**WELWYN HATFIELD BOROUGH COUNCIL
EXECUTIVE DIRECTOR - PLANNING, PUBLIC PROTECTION AND GOVERNANCE**

DELEGATED APPLICATION

Application No: 6/2021/1107/HOUSE
Location: 379 St Albans Road West Hatfield AL10 9RU
Proposal: Erection of a single storey rear extension, a two storey rear, front side extension, a roof extension and insertion of a rear box dormer.
Officer: Mr Raymond Lee

Recommendation: Refused

SCALE	1:100 @ A3
DATE	20210318
DRAWN	SDJ
DRAWING No	102

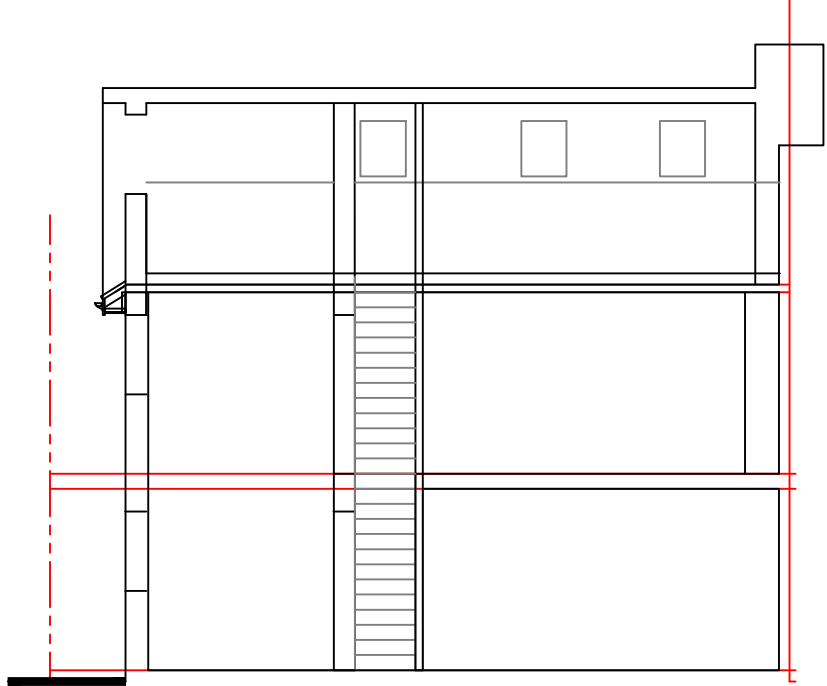
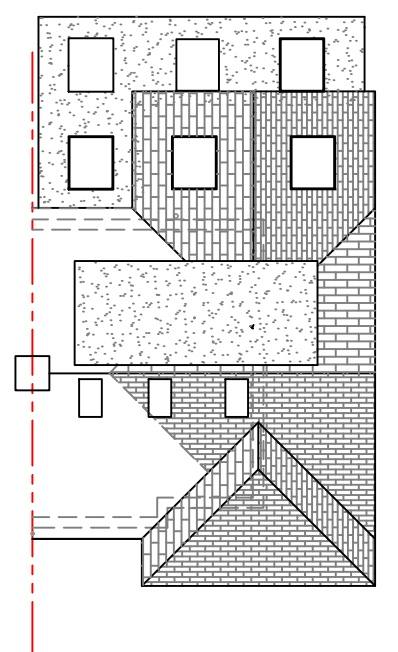
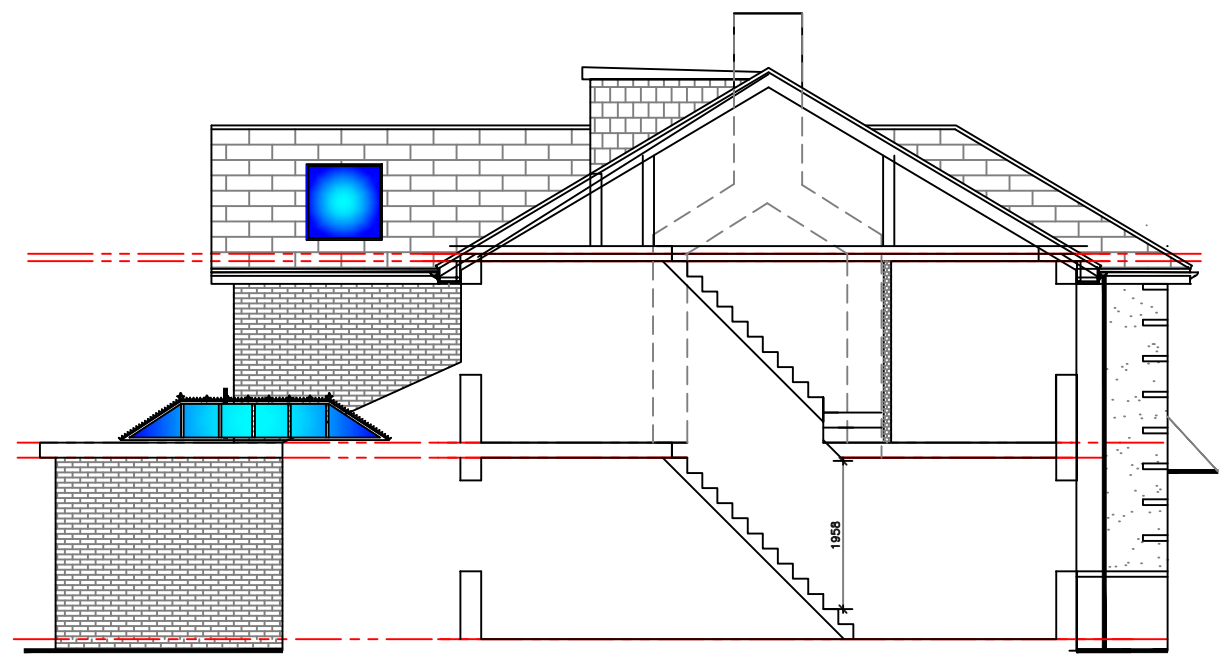
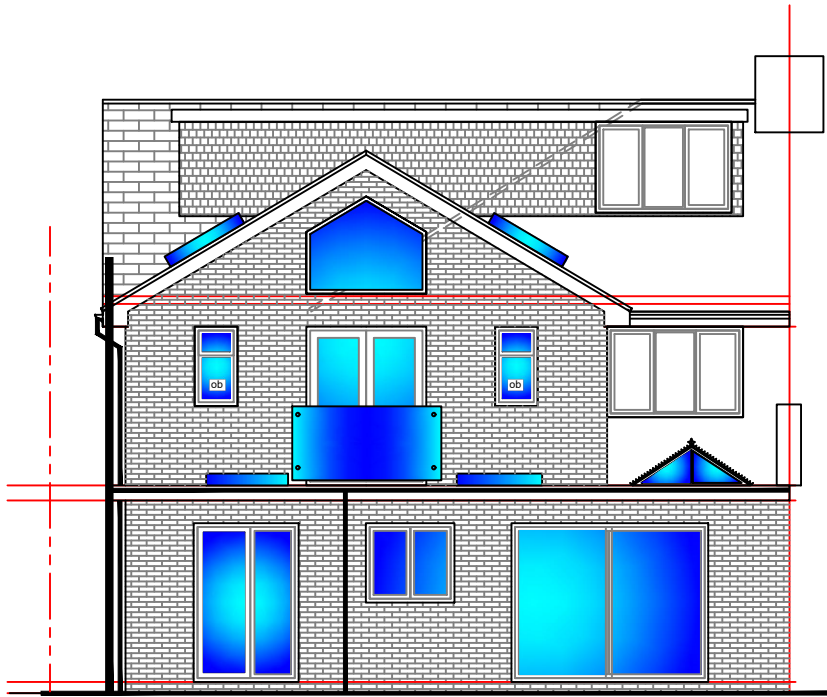
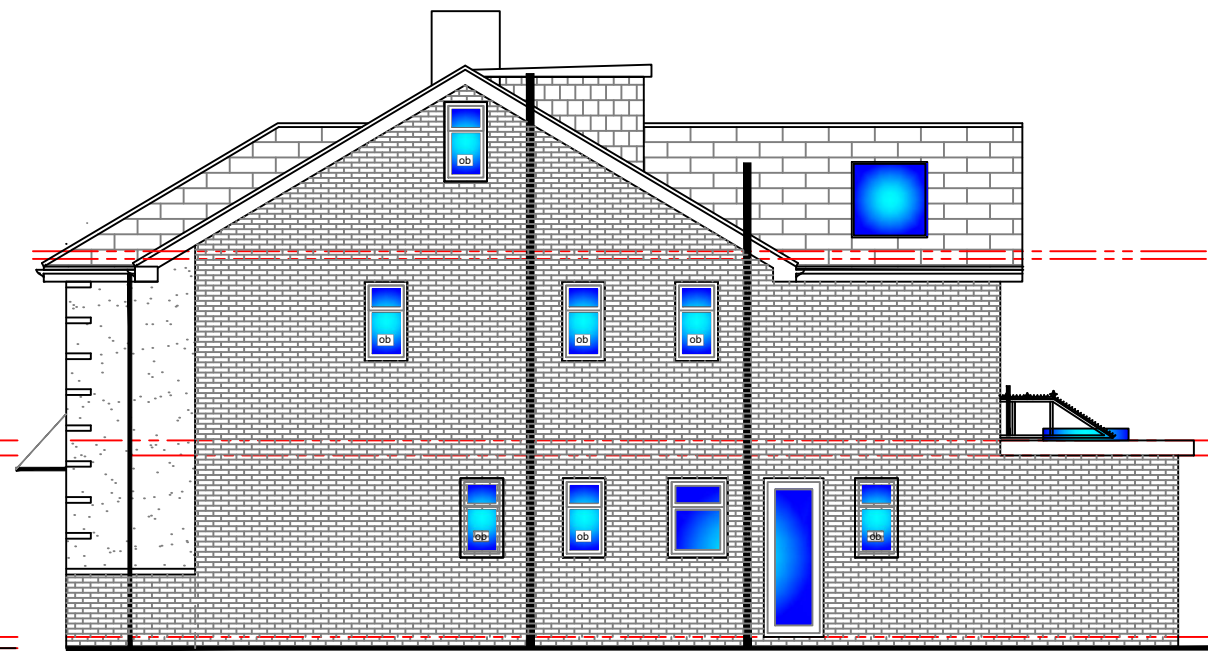
<p>Main Issues</p>	
<p>Design (form, size, scale, siting) and Character (appearance within the streetscene)</p>	<p>The National Planning Policy Framework (NPPF) chapter 12 emphasises the importance of good design as a key aspect of sustainable development. Paragraph 124 advises that the creation of high quality buildings and places is fundamental to what the planning and development process should achieve and that good design is a key aspect of sustainable development. Paragraph 127 the NPPF further advises that decisions should ensure developments will function well, be visually attractive, sympathetic to local character and establish a strong sense of place. Paragraph 130 is clear that “Permission should be refused for development of poor design that fails to take the opportunities available for improving the character and quality of an area and the way it functions...”.</p> <p>District Plan Policy GBSP2 of the Welwyn Hatfield District Plan 2005 notes that development within the specified settlements will be limited to that which is compatible with the maintenance and enhancement of their character. Policies D1 and D2 aim to ensure a high quality of design and to ensure that development respects and relates to the character and context of the locality, maintaining and where possible enhancing the character of the existing area. These policies are expanded upon in the Council’s Supplementary Design Guidance (SDG) which requires the impact of a development to be assessed giving regard to the bulk, scale and design of the proposal and how it harmonises with the existing building and area.</p> <p>In this case, substantial extensions are proposed to the original building. Although the footprint of the proposed development in comparison to the size of the plot is not considered to result in overdevelopment of the site, given the significant bulk that would be added to the front, side and rear of the building at</p>

<p>both ground and first floor level, it is not considered that these additions would be subordinate or subservient to the original dwelling.</p> <p>Whilst the principle of a well designed two storey side extension is not unacceptable in the area given the various examples that could be found along the street, in this instance the proposed two storey side extension would alter the current characteristic hipped roof to a much more prominent gable end that would visually unbalance the pair of semi's by creating a bulky roof on one side. This in addition to the other extensions proposed to the roof would significantly increase its massing and fundamentally change the appearance of the roof form. This part of the scheme would therefore fail to respect and relate to the host dwelling and the other pairs of semi-detached properties along the row.</p> <p>In terms of the two storey front extension, due to its excessive width and off centre location, it would result in a unduly prominent feature of the principle elevation of the property and would fail to appear as a subordinate addition. Furthermore, as there are no other examples of two storey front extensions in the immediate area, this would also result in a marked change in the character and appearance of this row of semi-detached properties.</p> <p>Although the proposed two storey element of the rear extension is appropriately stepped down from the main roof ridge, its width is greater than that of the two storey part of the original dwelling and therefore it is considered to be excessive in scale. With respect to the proposed box dormer to the rear, it is important to note that the Council's Supplementary Design Guidance states that dormer windows should be contained within the roof slope, be subservient to the roof, be set in by at least 1m flank wall/party wall of the property and be in proportion to the existing fenestration. In this case, since the proposed dormer is set in only approximately 0.6m from the common boundary with No. 377, this is considered contrary to the SDG. Although it is set down from the ridge and back from the eaves, given the extent of which it spans across the building, it would not be considered a subordinate or subservient addition to the existing roof slope.</p> <p>In terms of the detailed character of the development, the size, proportions and appearance of the doors and window being proposed is not, on balance, considered to harm the appearance of the dwelling or the character of the area. It is also proposed to utilise materials that would match the existing property which could be secured via condition in the event of an approval. This does not however overcome the harm in relation to the bulk and design of the proposals identified above.</p> <p>Cumulatively, the proposed extensions would overwhelm and dominate the original building, obscuring its original design and proportions and would fail to respect the character of the area. The proposed development is therefore excessive and of a poor standard of design that is contrary to the NPPF and Policies GBPS2, D1 and D2 of the District Plan which attach great importance to the design of the built environment and the SDG which seeks a design led approach to development.</p>

<p>neighbours would be those located to either side of the application site (No. 377 and No. 381 St Albans Road West).</p> <p>The neighbours at No. 377 have objected to the scheme on grounds of overshadowing to their living room from the single storey extension. Whilst the proposal would extend approximately 5 metres along the shared boundary with this neighbour, there is currently a circa 2m extension at No. 377 and therefore the proposal would only extend approximately 3 metres beyond their rear building line. Given that a relatively low flat roof form is proposed and the fact that No. 377's living room is served by a set of patio doors, it is not considered that this part of the scheme would result in significant loss of light or appear unduly dominating. The two storey part of the rear extension would be set in approximately 2.5m from the boundary and therefore it would not result in detrimental loss of light or outlook. In terms of privacy, whilst there are a series of side facing windows proposed which could afford views onto the neighbouring property at No. 377, since these openings serve non-habitable rooms, it would be considered reasonable and appropriate to obscure glaze these windows by condition in the event of an approval to overcome the privacy issue.</p> <p>As for the neighbour on the other side at No. 381, given the location of the development in relation to their primary windows and main amenity areas, it is judged that the proposal would not have an unacceptable impact on the levels of light or outlook. In terms of privacy, there are no side window proposed that would face onto these neighbours and the additional rear facing openings would not afford greater views than the current situation that would impinge on their privacy.</p> <p>Overall, subject to conditions in the event of an approval, the proposal would broadly comply with Policies D1 of the District Plan; the Supplementary Design Guidance and NPPF in relation to maintaining the living conditions of any neighbours.</p>

<p>Any other considerations</p>	<p>None.</p>
<p>Conclusion</p>	
<p>Having regard to the above, the proposed extensions, by virtue of their scale, form and design fails to reflect the proportions of, or be subordinate in scale to, the original dwelling. The proposal would therefore result in visually over dominant additions to the dwelling which fails to reflect the design and character of the property and which would be detrimental to the character of the streetscene. Accordingly the proposal represents a poor standard of design that would be contrary to policies D1</p>

1. The proposed extensions, by virtue of their scale, form and design fails to reflect the proportions of, or be subordinate in scale to, the original dwelling. The proposal would therefore result in visually over dominant additions to the dwelling which fails to reflect the design and character of the property and which would be detrimental to the character of the streetscene. Accordingly the proposal represents a poor standard of design that would be contrary to policies D1 and D2 of the Welwyn Hatfield District Plan 2005, the Supplementary Design Guidance 2005 and the National Planning Policy Framework .
